DELEGATED ITEM FILE REPORT - REFUSAL

Application No:	3/2011/0778
Development Proposed:	Retrospective installation of a new window to the side elevation at Strathaven, Whalley Road, Billington, BB7 9LG

EXISTING PLANS AND ELEVATIONS

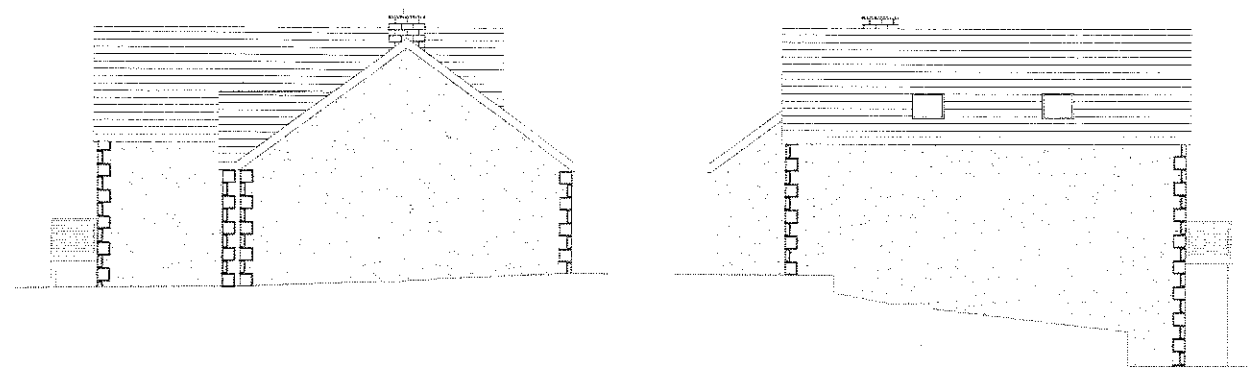
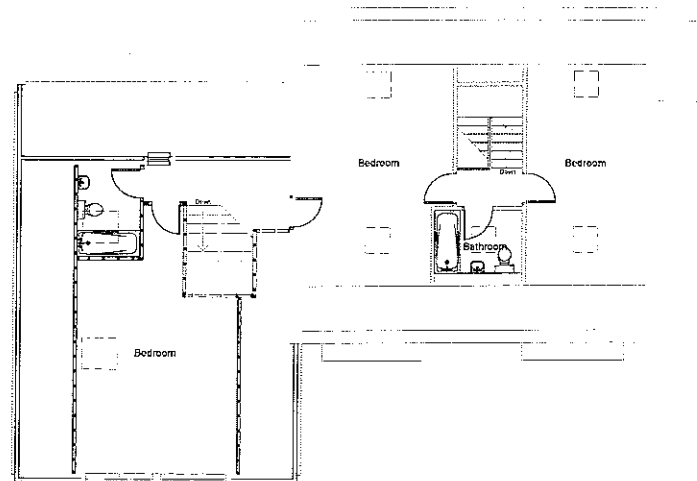
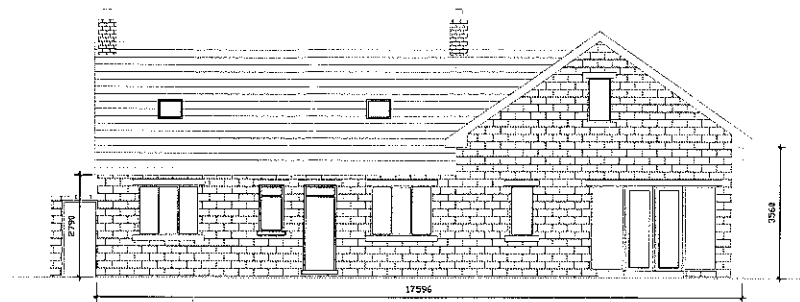
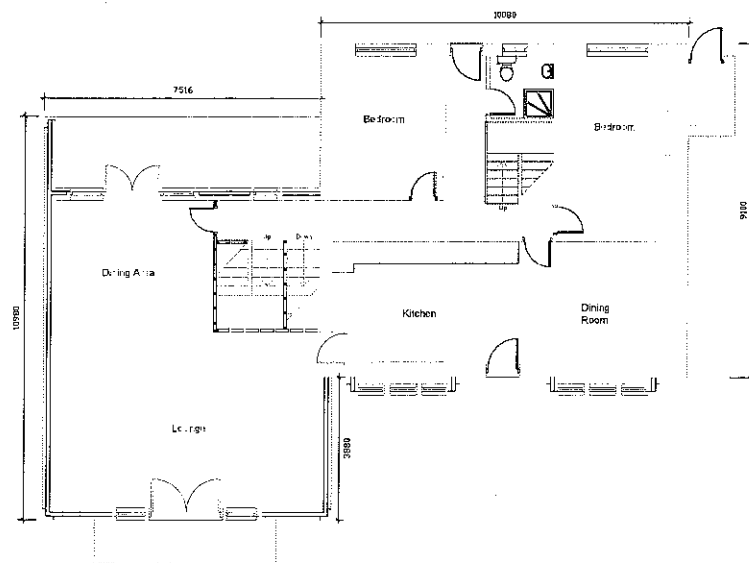
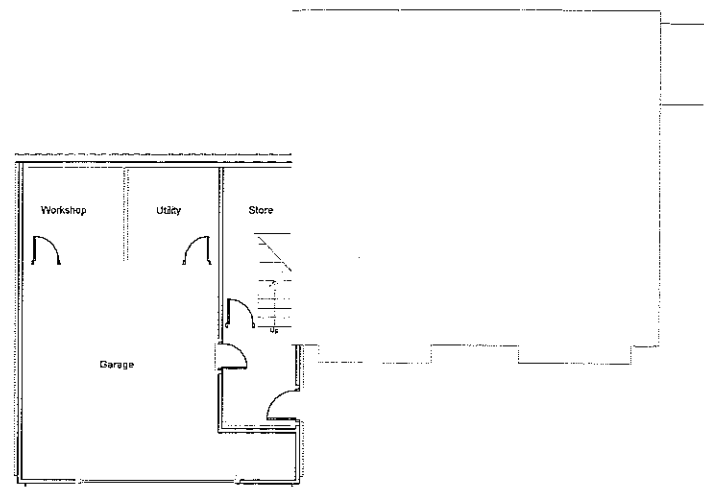
Retrospective planning permission is sought to insert a ground/ first floor window in the side elevation of the property with approximate dimensions of 1.8m length x 1.37m in height. The window is approximately 3.8m above ground level and is clear glazed. The plans illustrate a window with a stone head and sill, however, a window with a stone surround has been inserted.

The window in situ is clearly contrary to this guidance. The window directly overlooks the neighbours bow window serving a lounge, a habitable room and the front main garden area of the adjacent property (Gunnarside). The position of the window allows views in to the neighbour's bay window giving the feeling of being overlooked; in addition, the window enables open views into the front main garden area. Prior to the window being inserted, these neighbours enjoyed the privacy of their front garden area not being directly overlooked. I consider this elevated window seriously intrudes on the privacy and enjoyment of the neighbours garden area as to have the window so high above them and with the ability of persons to look down upon them, to be somewhat intimidating and detrimental to the privacy and enjoyment of this property. I consider this to represent a sustainable reason for the refusal of the application.

RECOMMENDATION: That permission be refused and enforcement action be taken to ensure the removal of the window.
